Andrew Beattie - Berry Bypass

The Issues Associated with the Design of the Proposed Relocation of the Berry Equestrian Centre

This submission concerns the impact of the proposed Foxground and Berry Bypass on the Berry Equestrian Centre which is located in North Street Berry.

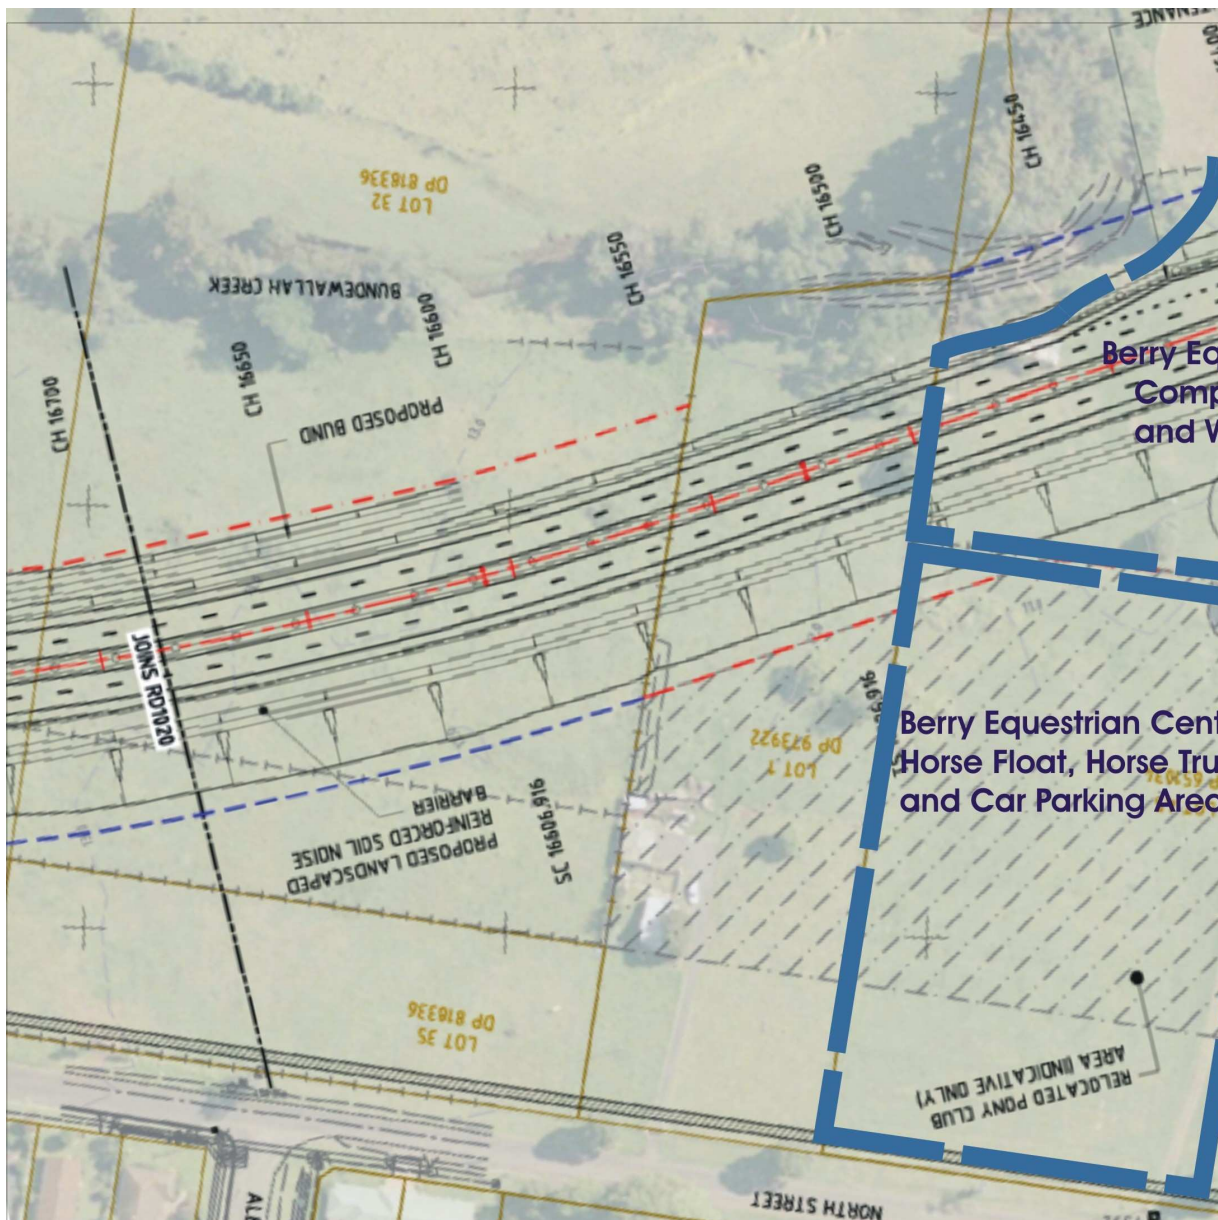
The design and loss of land of the proposed relocation of the Berry Equestrian Centre will have a significant impact on the ability to conduct events. It will impact riders, participants and spectators in the following ways.

1. The competition grounds are required to be rectangular /square in shape of a minimum size of 140 metres x 140 metres with a level, well drained, good riding surface in order to cater for at least 4 dressage arenas or 2 showjumping arenas.

2. The parking area is required to be of a minimum area equivalent to 90 metres x 160 metres and allow for easy entry, maneuverability, parking and exit of horse floats and trucks. Each parking space is equivalent to an absolute minimum of 4 normal vehicle spaces due to the need for unloading/loading and tie up areas for horses.

3. There is concern for the safety of horses, riders and the general public due to the near location of the proposed riding area to the 4 lane expressway, the skateway, the public cycleway/walkway and North Street. There will be anticipated significantly increased noise and visibility of cars and trucks travelling at 100km/hour on the expressway with horses competing nearby, often with young, very inexperienced riders.

4. Access to the grounds is likely to be across a public shared cycleway/pathway. The safety of children on skateboards, bicycles etc are at risk as horse trucks and floats cross the pathway. Horse floats and trucks also require an indented driveway of at least 15 metres to allow vehicles to park off the roadway whilst gates to the grounds are opened.
